# KITITAS COUNTY

## DEPARTMENT OF PUBLIC WORKS

**TO:** All Staff  
**FROM:** Public Works Plan Review Team  
**DATE:** February 12, 2026- UPDATE March 20, 2026  
**SUBJECT:** BL-26-00001 Fields

# RECORD OF SURVEY

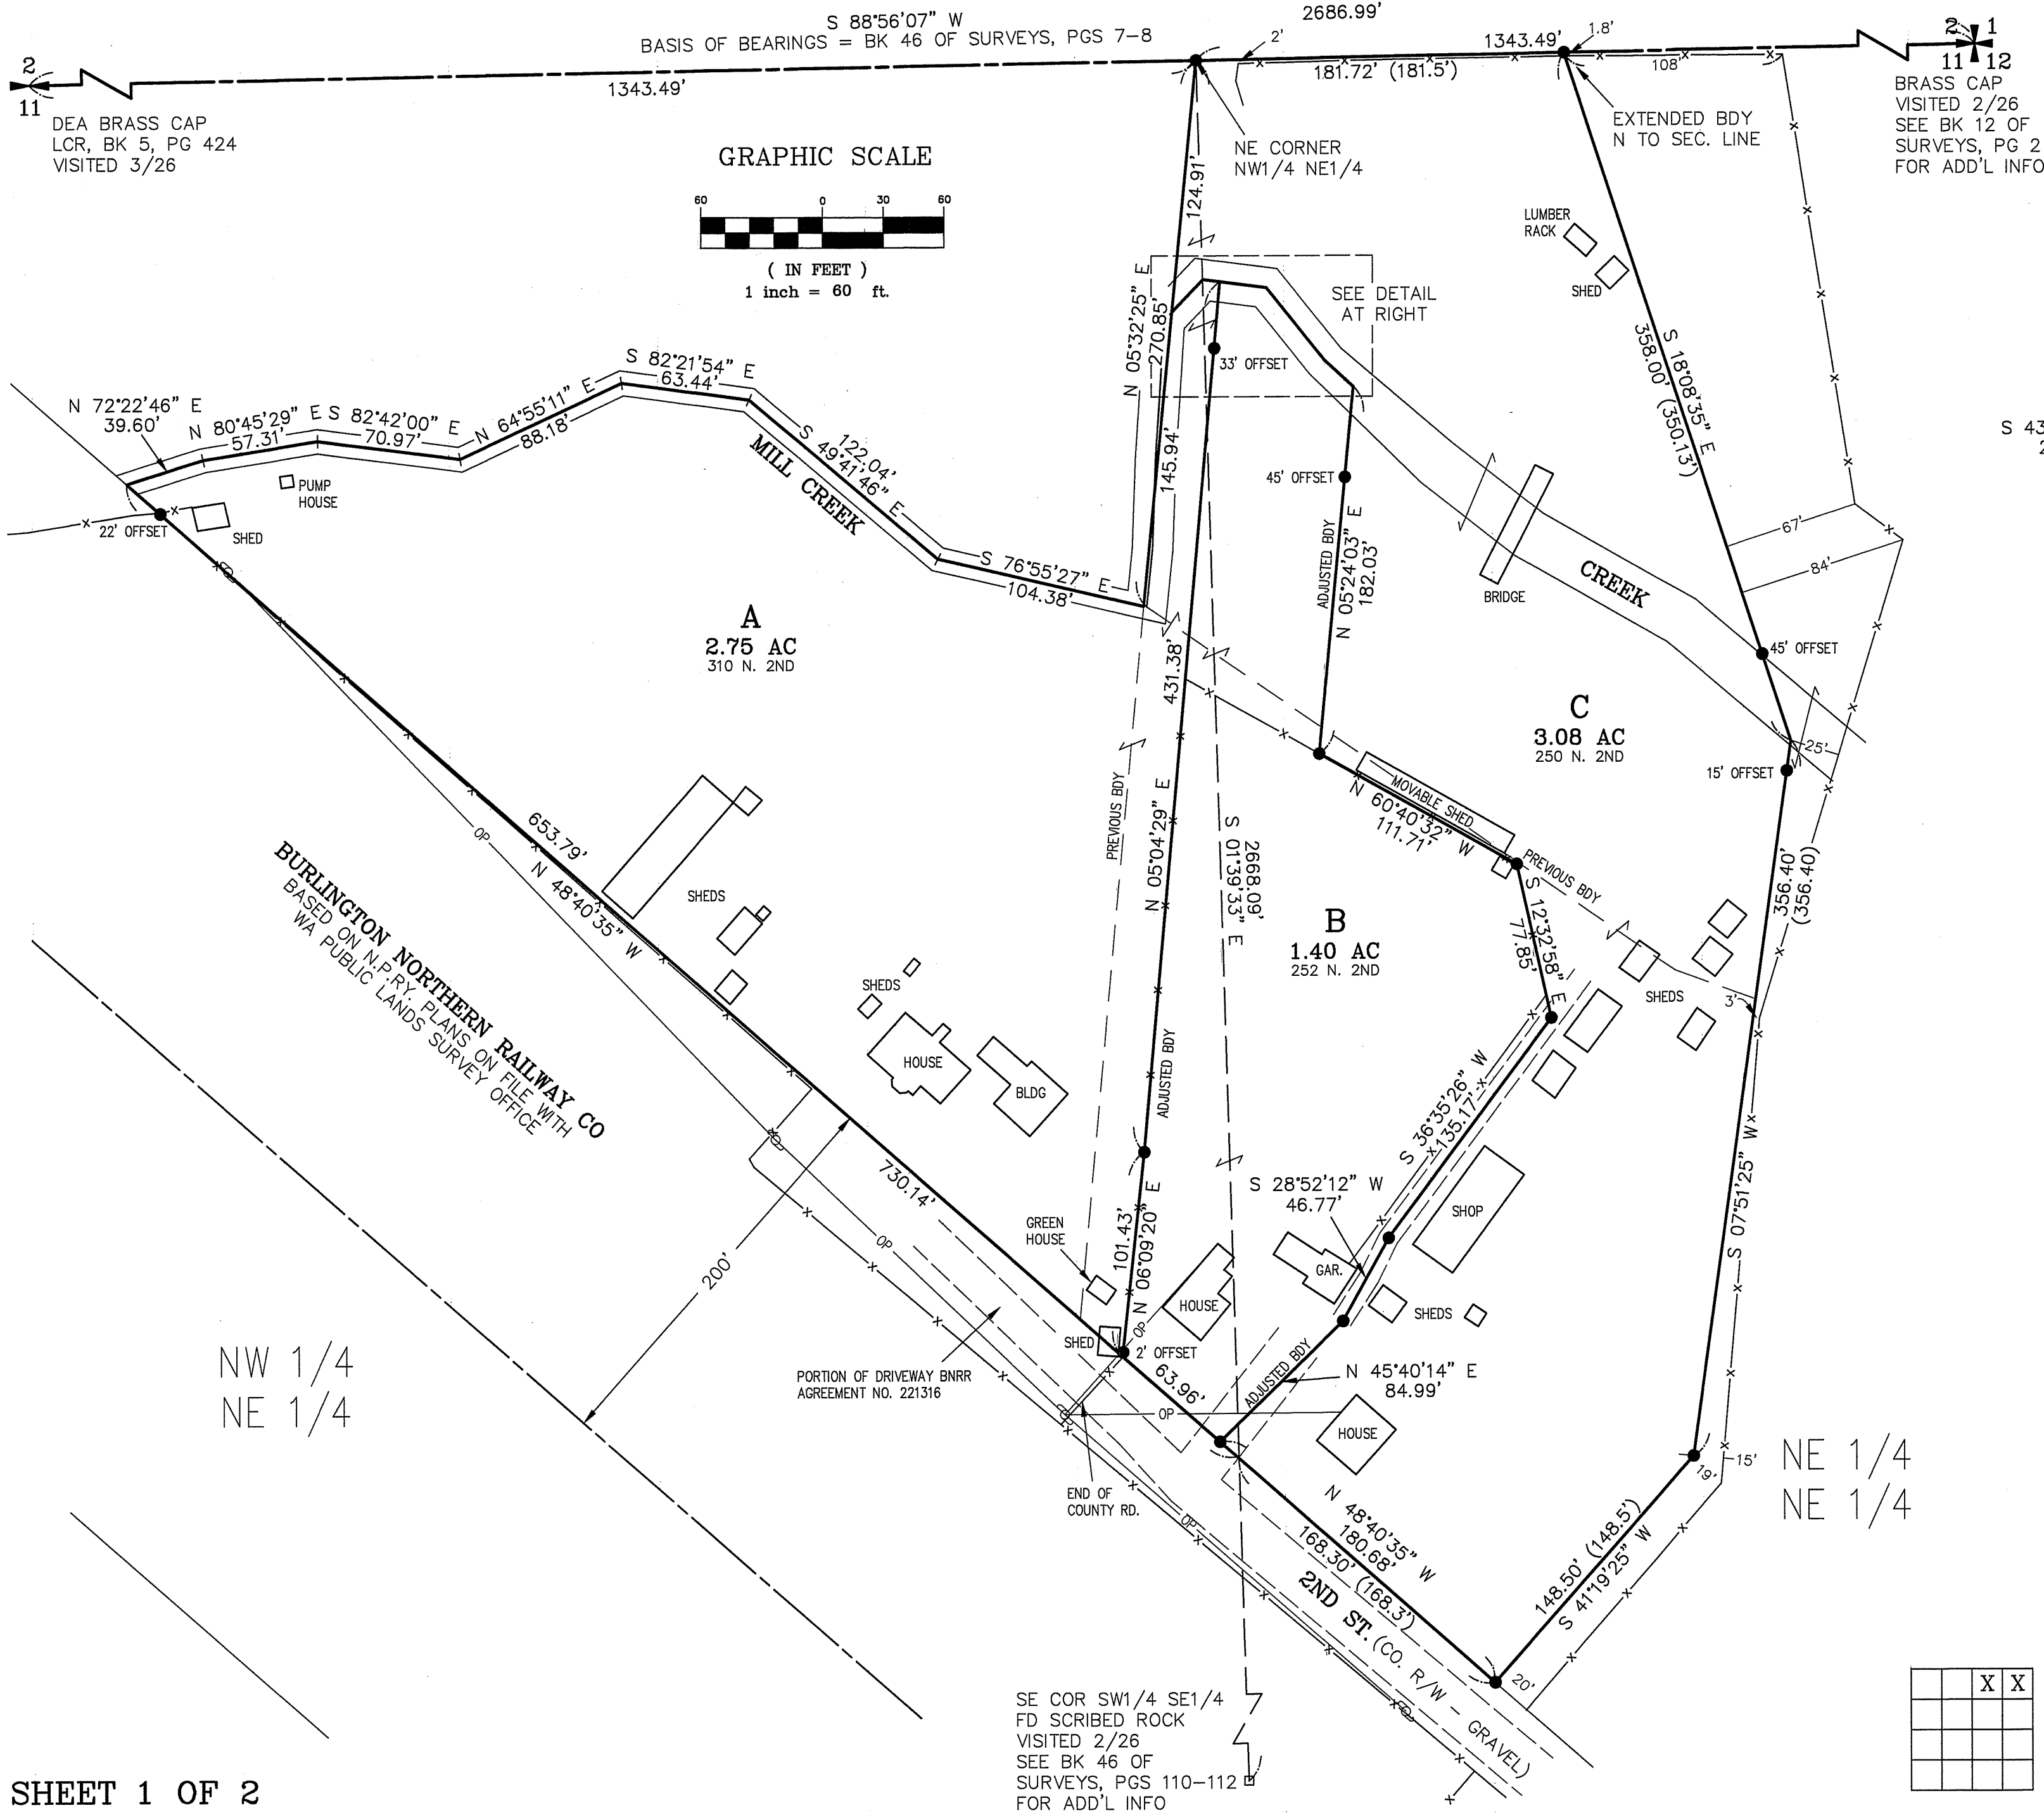
<b>ACCESS</b>	<ol style="list-style-type: none"> <li>1. An approved access permit shall be required from the Kittitas County Department of Public Works prior to creating any new driveway access or altering an existing access.</li> <li>2. Maintenance of driveway approaches shall be the responsibility of the owner whose property they serve. The County will not maintain accesses.</li> <li>3. Any further subdivision or lots to be served by proposed access may result in further access requirements. See Kittitas County Road Standards.</li> <li>4. Provide proof of easement for shared driveway access to lots prior to final approval.</li> </ol> <p>In addition to the above-mentioned conditions, all applicable Kittitas County Road Standards apply to this proposal. Access is not guaranteed to any existing or created parcel on this application</p> <p>OF NOTE:  Parcel 745933 to retain address 310 N 2<sup>nd</sup> St ; It is unclear which home will retain 250 and 252 N 2<sup>nd</sup> St on parcel 685933.</p>

<b>ENGINEERING</b>	<p>Except as exempted in KCC 14.05.060, no grading or filling upon a site involving more than one hundred (100) cubic yards shall be performed without a grading permit from the County Engineer or Public Works designee (KCC 14.05.050). An application for grading in excess of five hundred (500) cubic yards shall be accompanied by an engineered grading plan (KCC 14.05.080). (CBP)</p>
<b>SURVEY</b>	<p>As the application does not contain a survey map, comments are herein reserved until final. (JT)</p> <p>UPDATE 03/16/2026</p> <ol style="list-style-type: none"> <li>1. Please show previous boundaries. Dimensions are not required.</li> <li>2. Please label 2<sup>nd</sup> street as “2<sup>nd</sup> Street (County R/W-Gravel)” or similar. Identifying R/W width is not required.</li> <li>3. Please identify “End of County Road” at the Gate located near the shared corner of Lots A and B.</li> <li>4. For Lot A driveway within the railroad right of way, please note railroad licence, agreement OR note “access by prescription”.</li> </ol>

<p>5. Per WAC update, legal descriptions must include legal description AND document sourced from. Please include reference to Title Report, Deeds, or Records of Survey that the legal descriptions were obtained from. (JT)</p> <p>Update 03/20/2026 All prior survey comments have been addressed on the most recent submittal. (JT)</p>
<b>TRANSPORTATION CONCURRENCY</b>	No transportation concurrency management application is required for this project as described.
<b>FLOOD</b>	Parcels 675933, 685933, and 745933 are completely within the FEMA mapped special flood hazard area (1 percent annual chance flood zone). All development within the special flood hazard area requires a floodplain development permit, including structures that are exempt from a building permit, and must follow the guidelines within KCC 14.08. (SC)
<b>WATER MITIGATION/ METERING</b>	No comments. (SC)
<b>AIRPORT</b>	Proposed project is not located within the Airport Overlay Zone.
